PORTLAND MAINE

June 6, 2013

RE: 40 Seashore Avenue, Peaks Island – 084-D-005, 006 & 007 – IR-2 Residential Zone- Permit #2013-01067 – unpermitted decks

**1 SITE PLAN**  
 Scale: 1/8" = 1'-0"

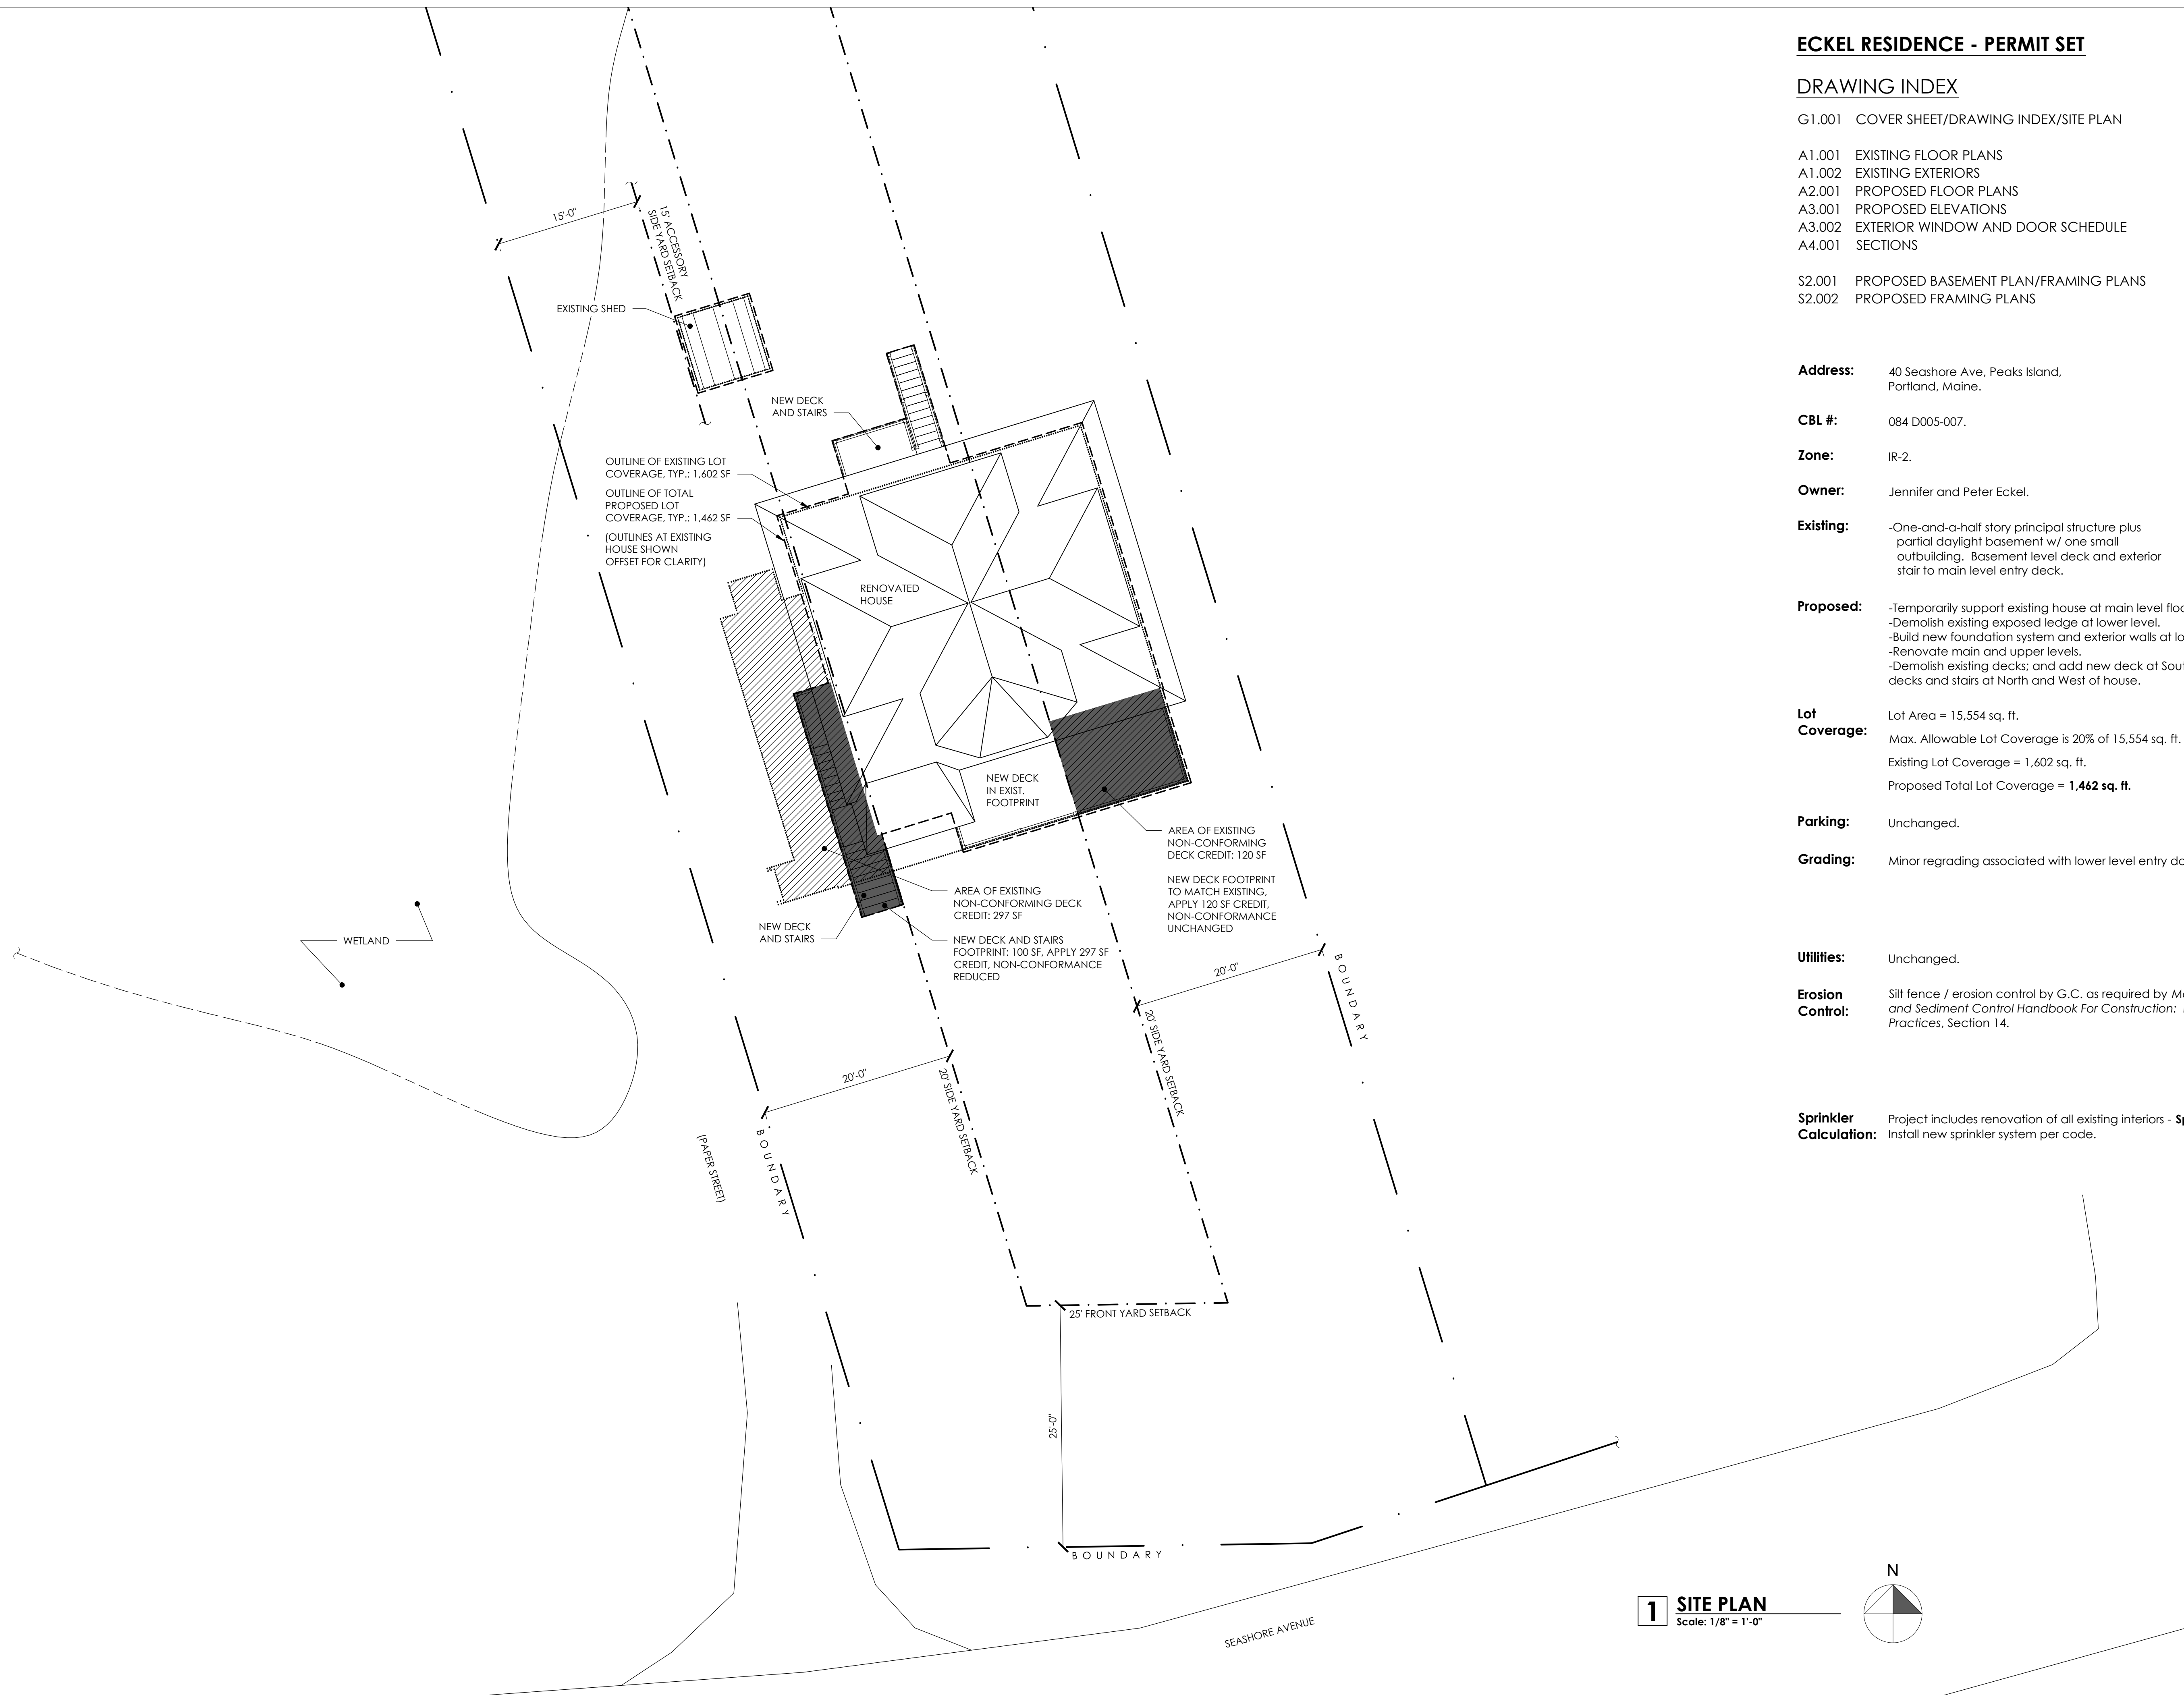
Part of the proposed work is to remove the existing 240 square foot deck on the south side of the house and rebuild it in the same footprint, and remove the 297 square foot deck on the west side and replace it with a landing and stairs to grade from the main floor. Both the right half of the 240 square foot deck and the 297 square foot deck are nonconforming as to the minimum side setback of twenty feet [section 14-145.11(c)(3)]. In order to be able to use the nonconforming footprints, the decks would have had to have been permitted. In checking both our files of old building permits and the assessor's pre-1957 card, I found no record of the two decks being permitted. Since they were not permitted, they are not legal and therefore they need to be removed. A deck can be built on the south side but it must meet the setback requirements. Since the twenty foot side setback encroaches on the left side of the house, the proposed landing and steps do not meet the setback and cannot be built.

Your permit is on hold until we receive revised plans that show that the footprint of the house meets the setback requirements. Also the shed meets the required setbacks for an accessory structure that is 144 square feet or less, but it was never permitted. It should be permitted after the fact as part of this permit.
